The Australian Hearing Hub Response to Agencies - Transport Issues

Arup prepared a Transport and Accessibility Impacts Report (16 June 2010) for the proposed Australian Hearing Hub (MP 10_0032). The following is a response to letters received from the following agencies:

Waterloo Road/Herring Road

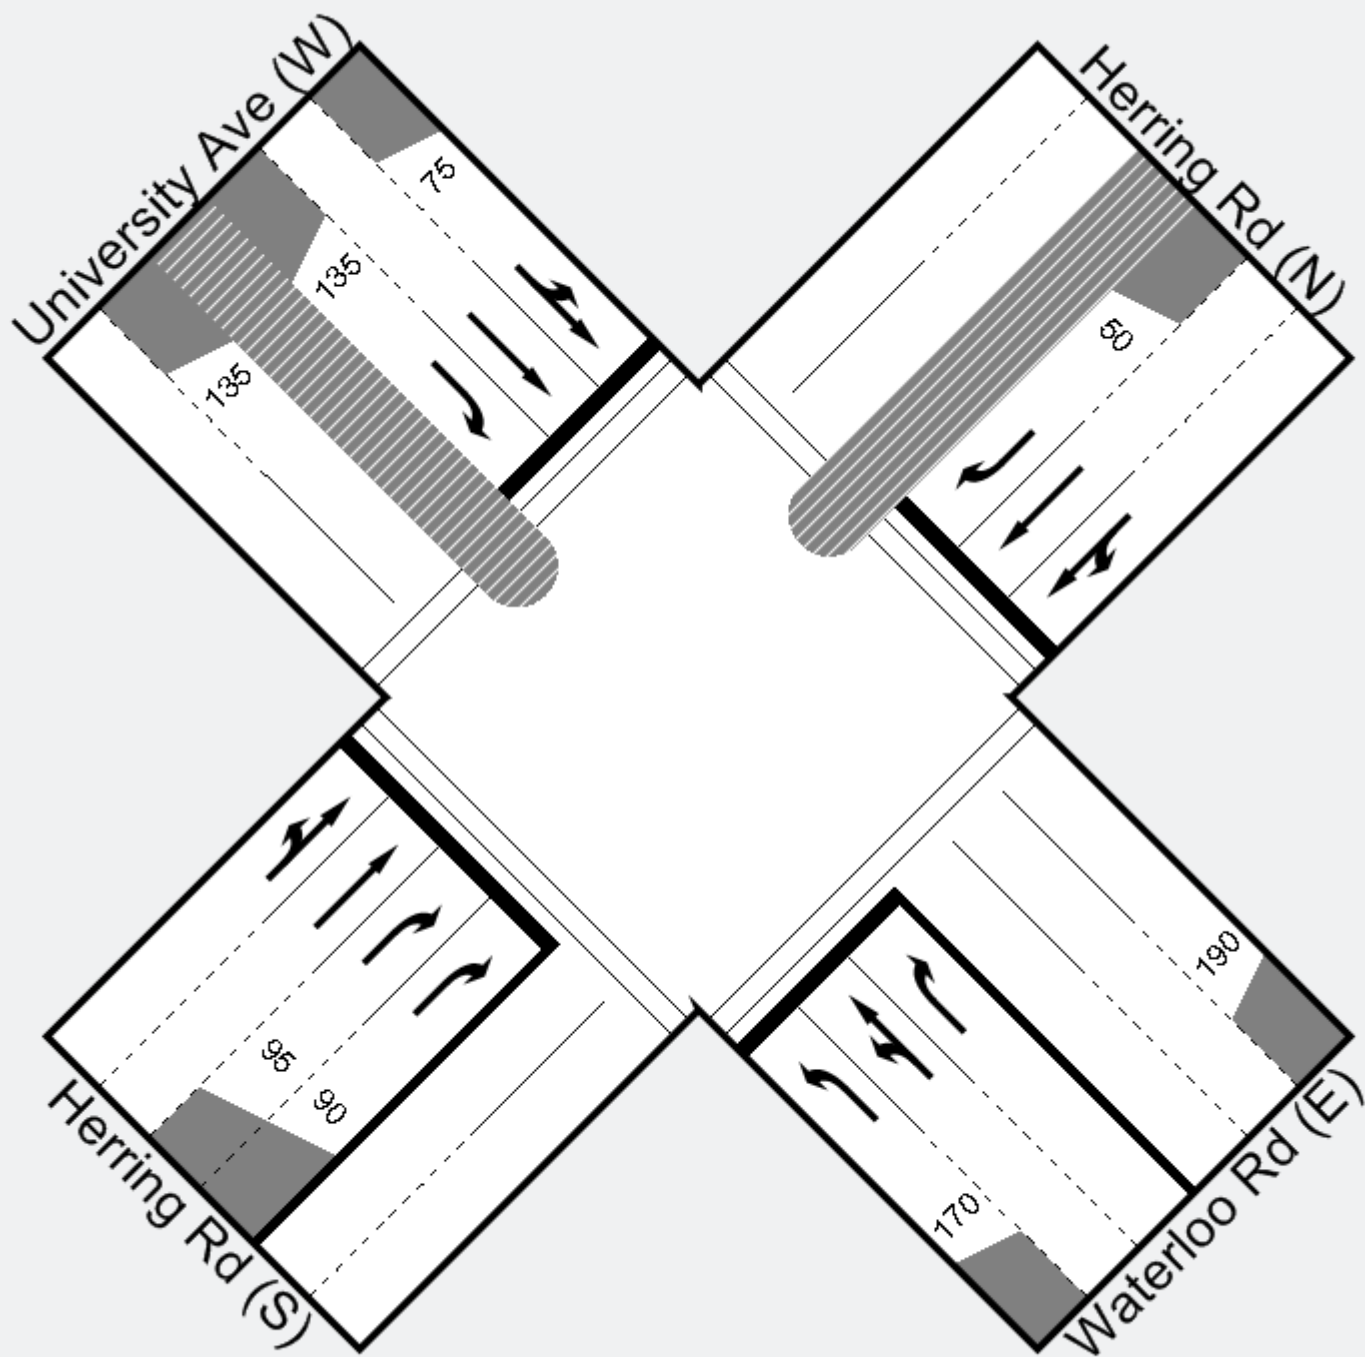
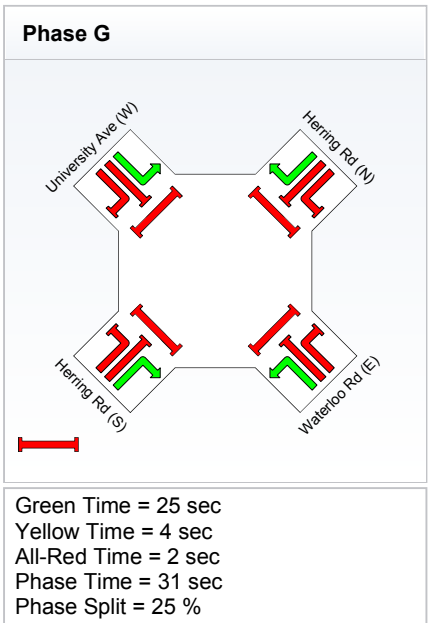
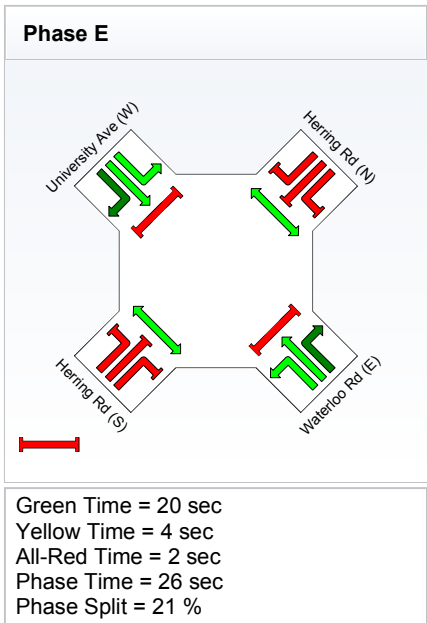
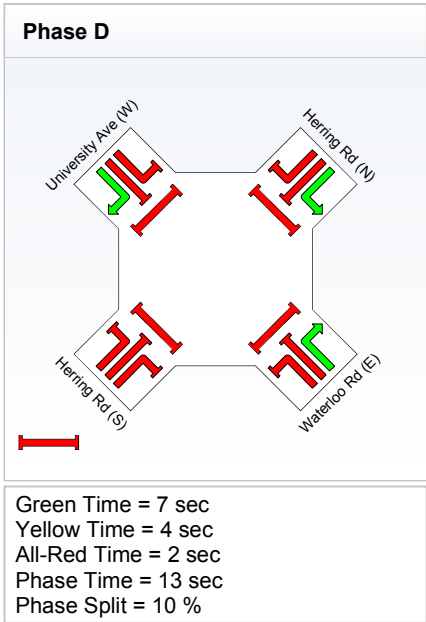
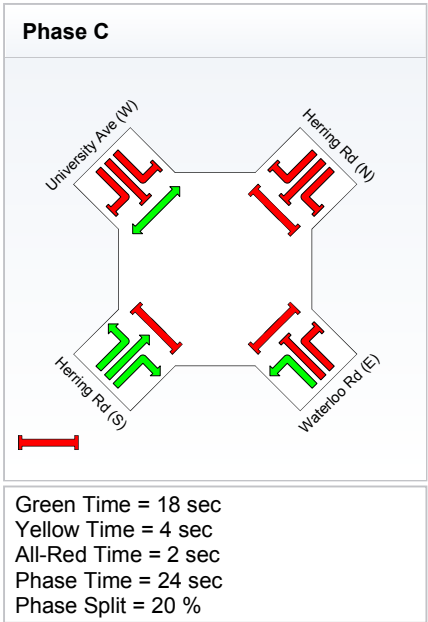
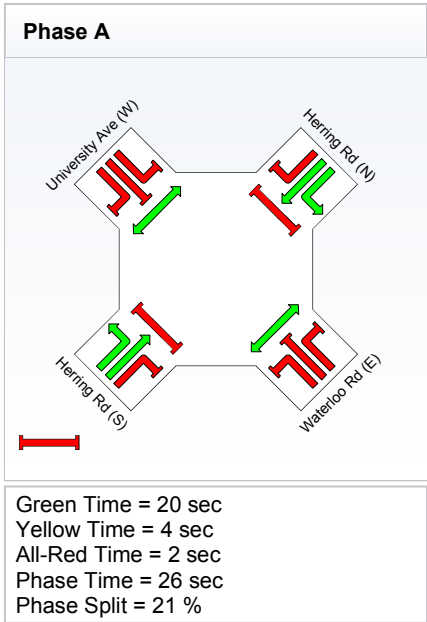
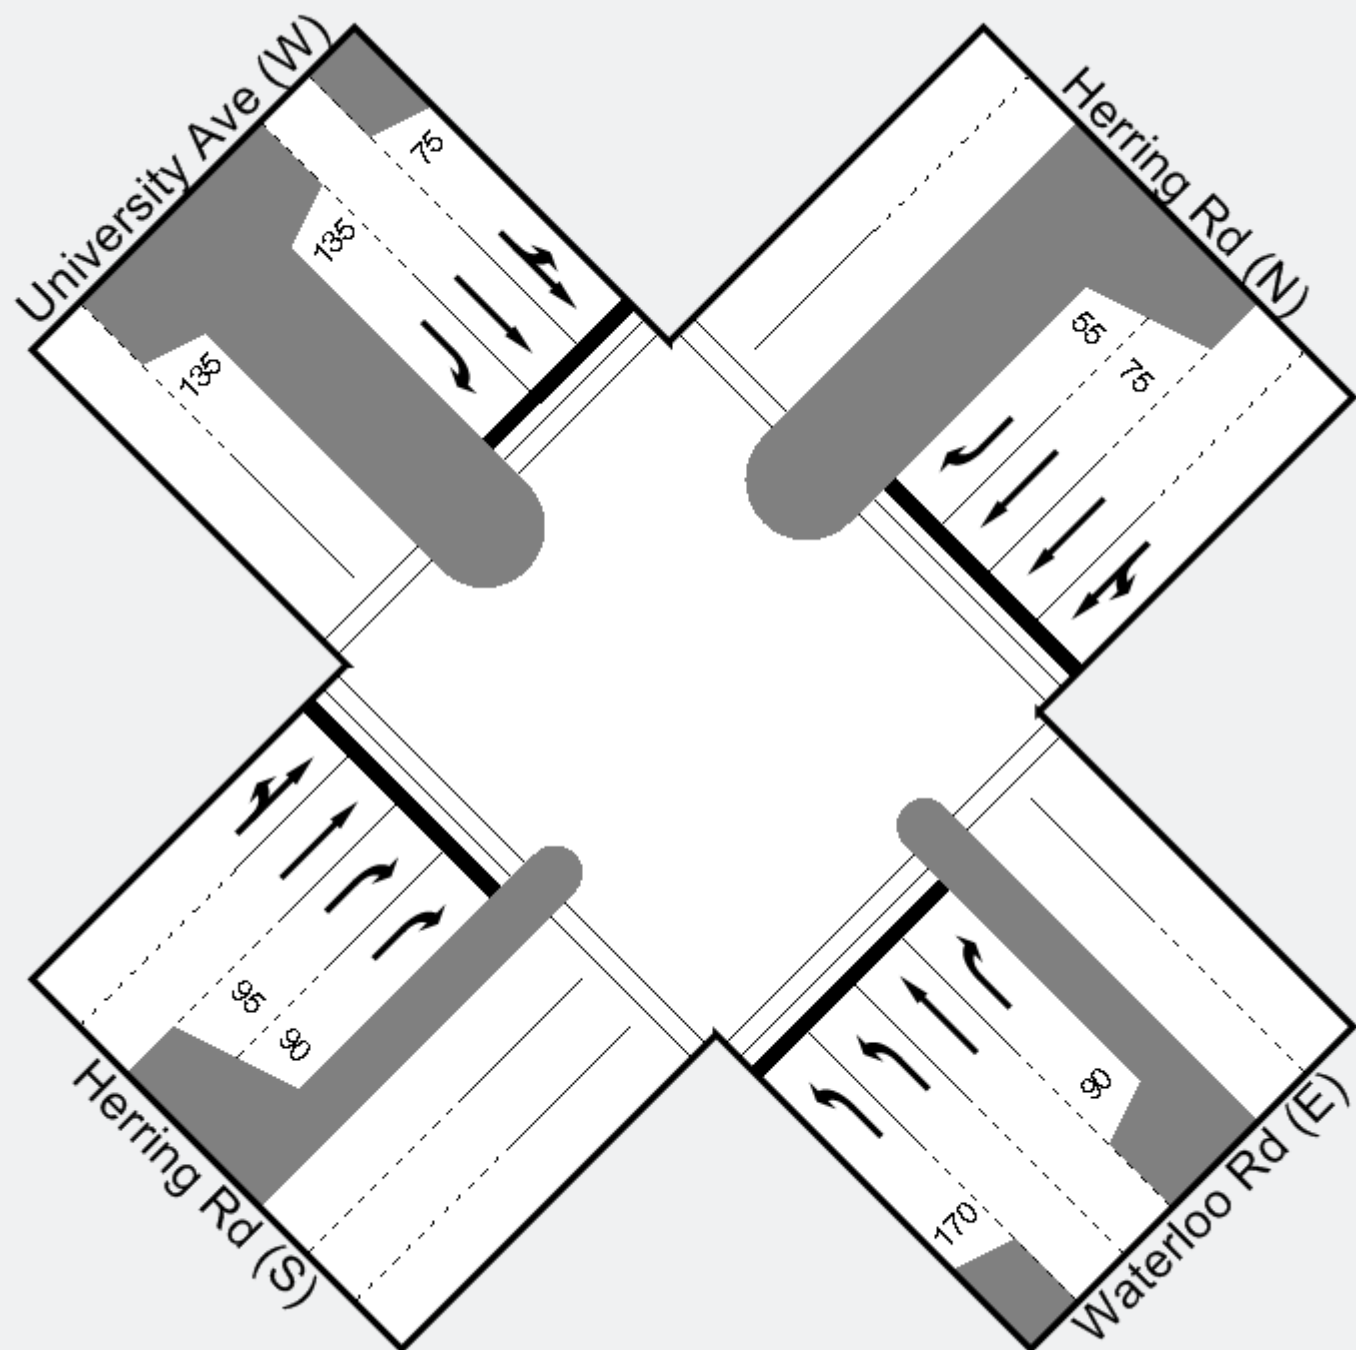
• *Waterloo Road and Herring Road – Traffic signal controlled. The preferred layout is different to that provided in the report. The current layout currently proposed by the RTA is:*

- Waterloo Road (east): L -150m, TL, R*
- Herring Road (south): LT, T, R-100m, R-90m. The departure is T, T.*
- University Road: LT,T,R*
- Herring Road (north): R-55m,T, T, L-55m*

The modelled layout was consistent with the layout proposed by the RTA at the time the modelling was undertaken in June 2010. Council will be aware that the RTA has since modified the design of the proposed improvements at this location. The modified design has been submitted to Council and was tabled at the Ryde Traffic Committee's September 2010 meeting. Sidra modelling undertaken by the RTA demonstrates that both the originally proposed layout and the currently proposed layout are likely to result in a similar level of intersection performance and therefore the modelling undertaken in June 2010 remains valid.

Epping Road/Balacclava Road

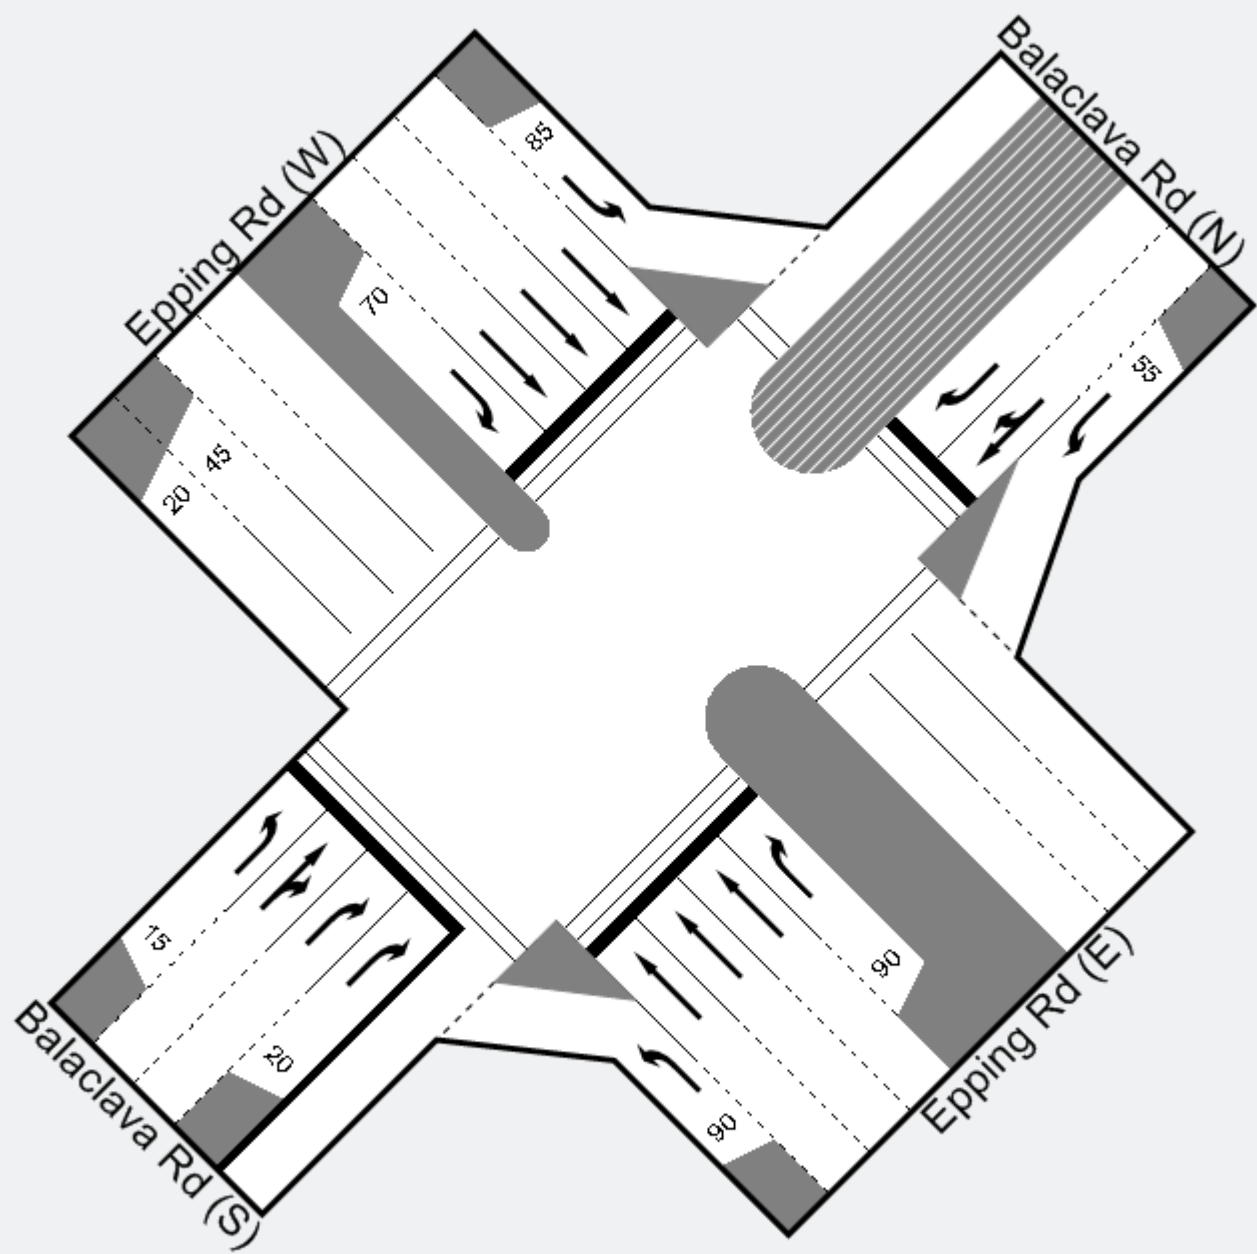
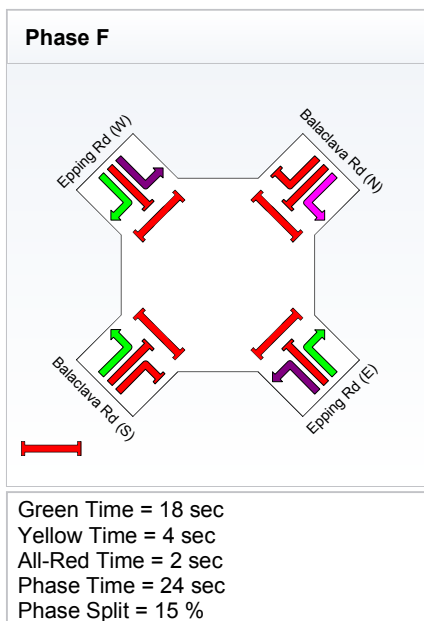
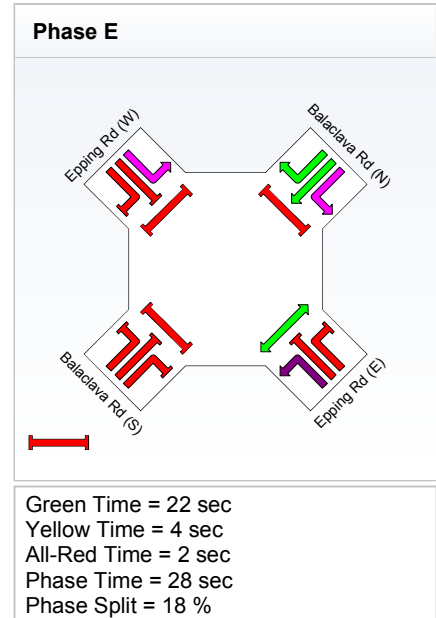
• *Balaclava Road and Epping Road – Traffic signal controlled. This is consistent with the existing layout although this intersection is to be upgraded by the RTA to include bus priority. In addition the relocated Macquarie Uni carpark will attract additional traffic movements. The additional traffic will put pressure on the capacity of the Epping Road east right-turn movement into Balaclava Road in the AM. That is, a second right-turn lane in Epping Road on the eastern approach is required.*

See Arup comment in Overview section.
